Consultee Comment for planning application 6/2019/2591/HOUSE

| Proposal | <input type="text" value="Erection of a ground floor side/rear and first floor extension, including the construction of a rear dormer and installation of rooflights to facilitate the creation of habitable space within the loft and erection of front boundary wall and gates"/> |
| Organisation | <input type="text" value="Northaw & Cuffley Parish Council"/> |

PROPOSED FRONT GATED WALL

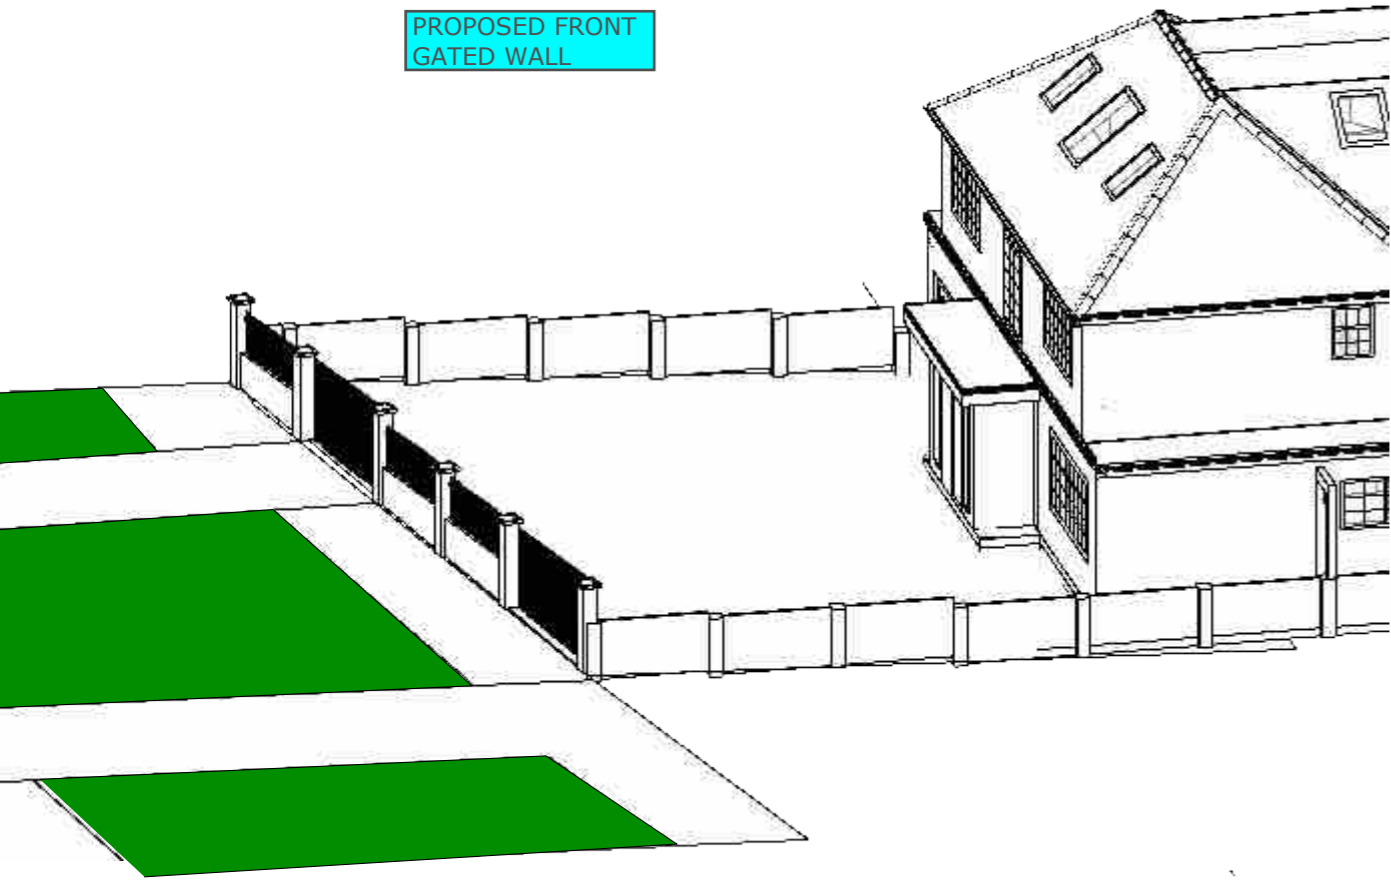
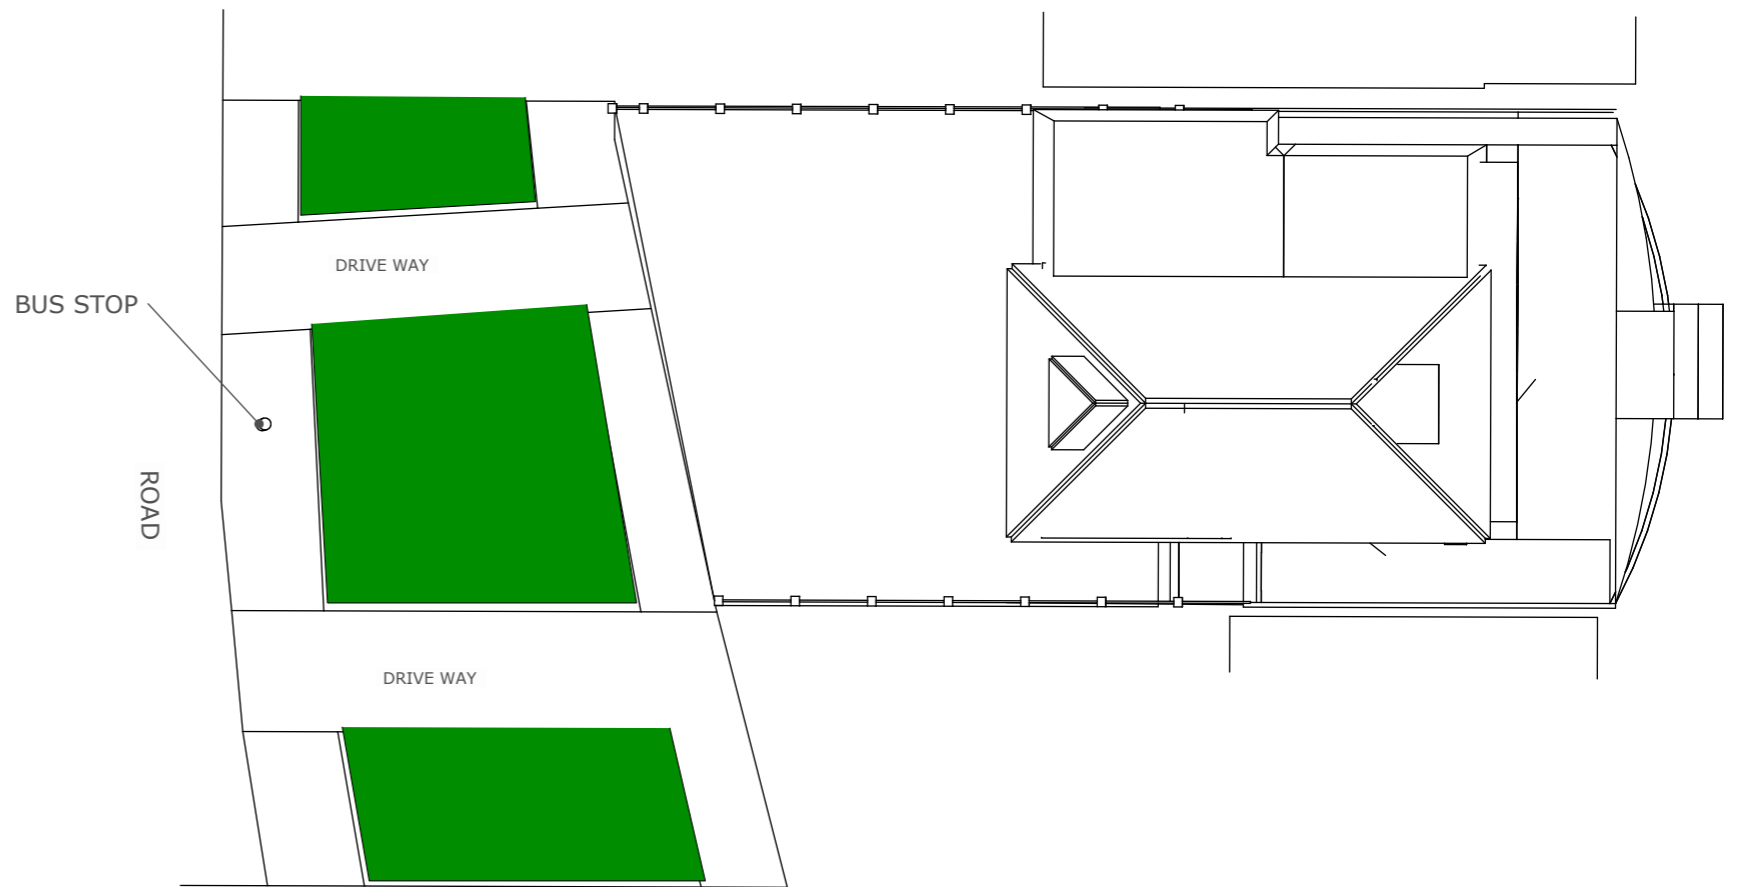
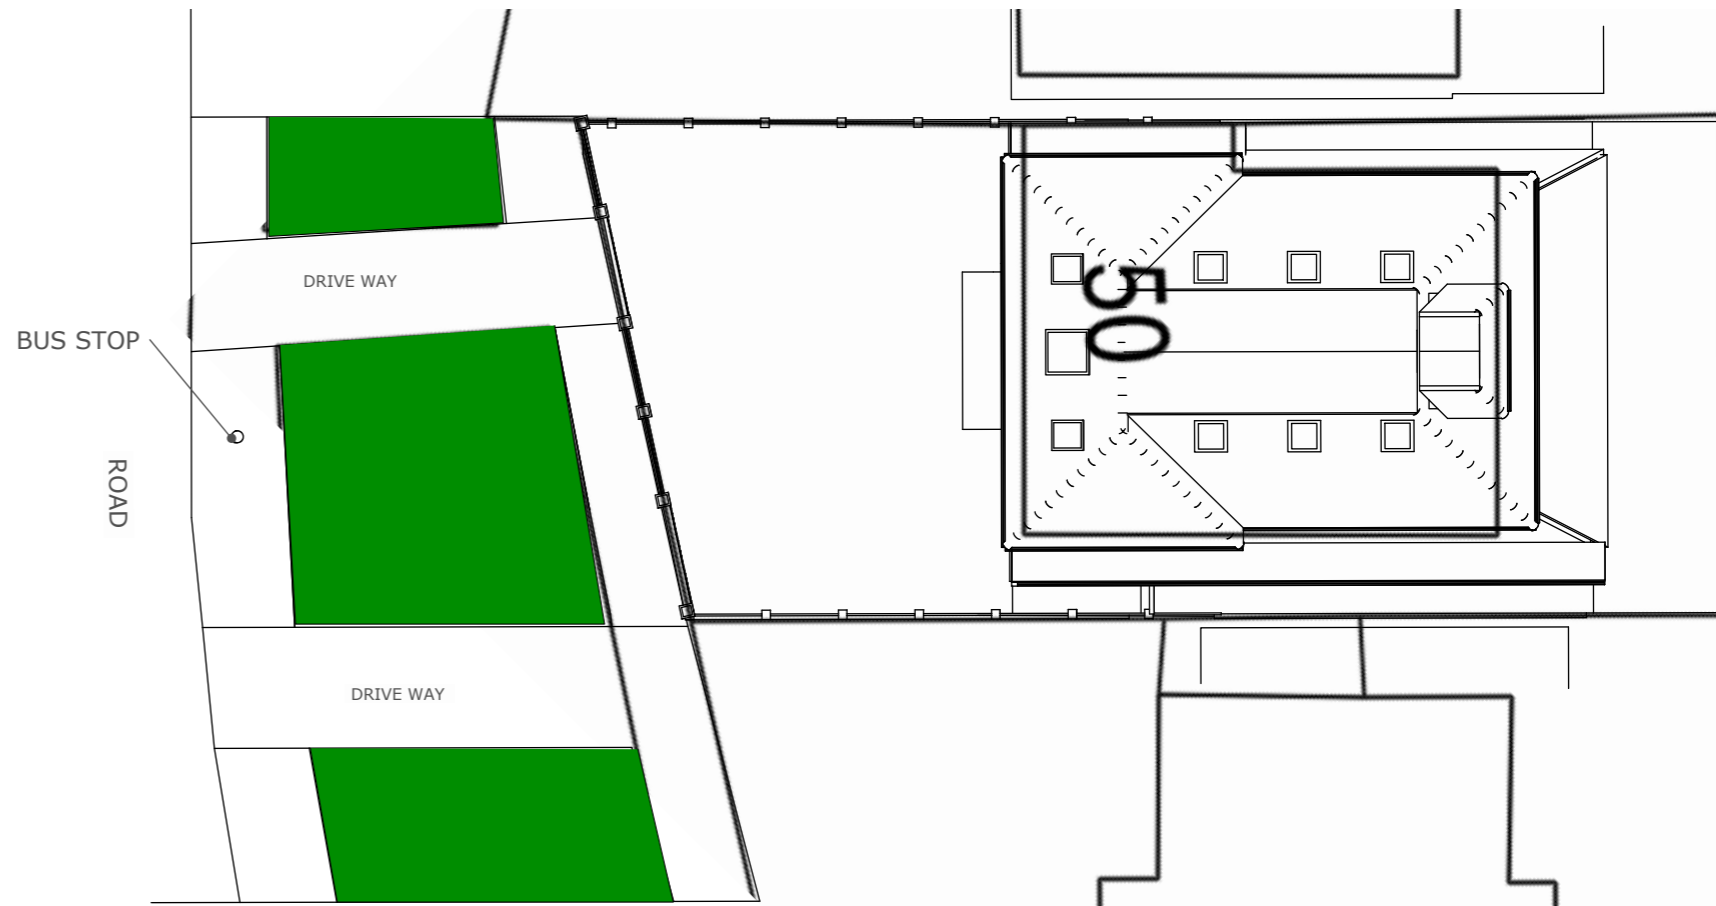
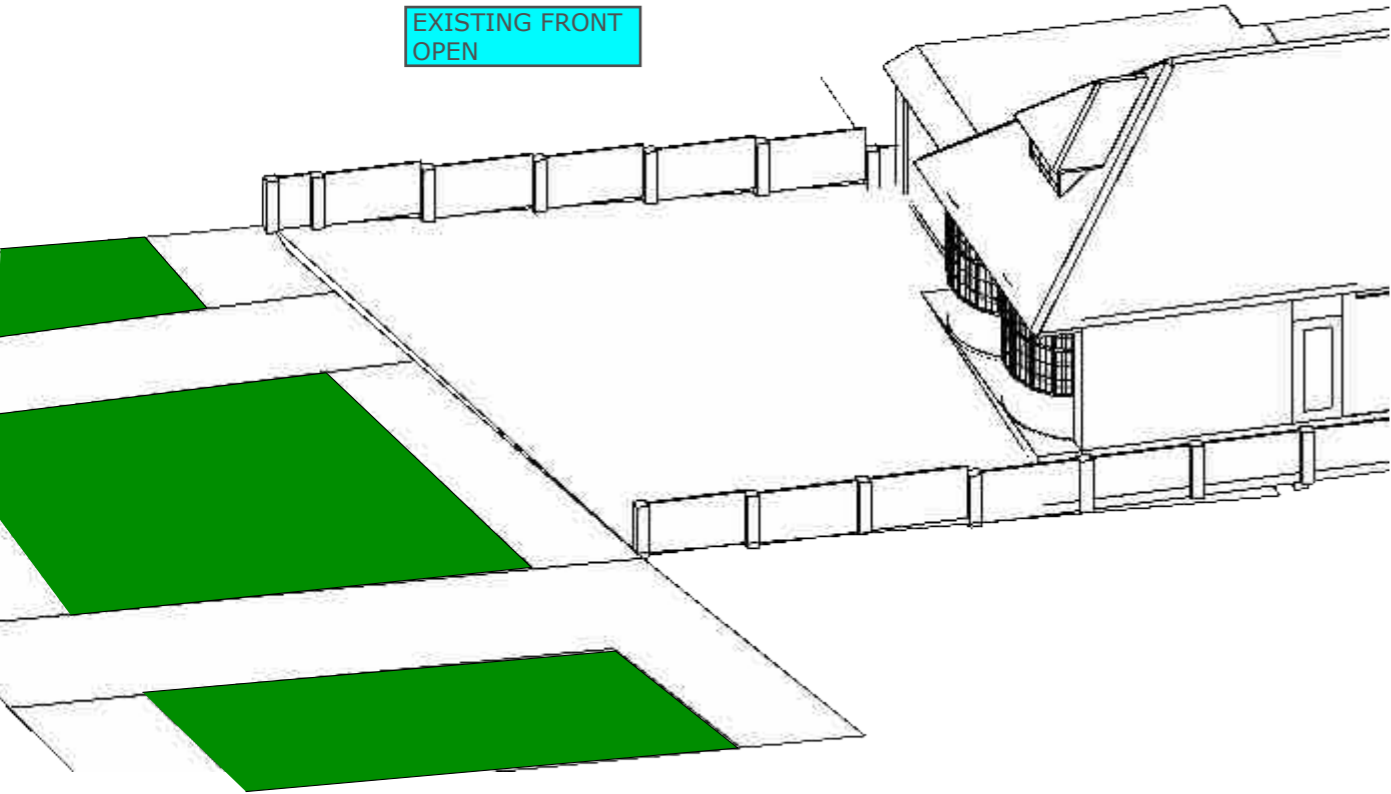
| Comments | <input type="text" value="The proposed wall and gates are out of keeping with the street scene. We are concerned about the possible removal of a mature tree within the front garden"/> |
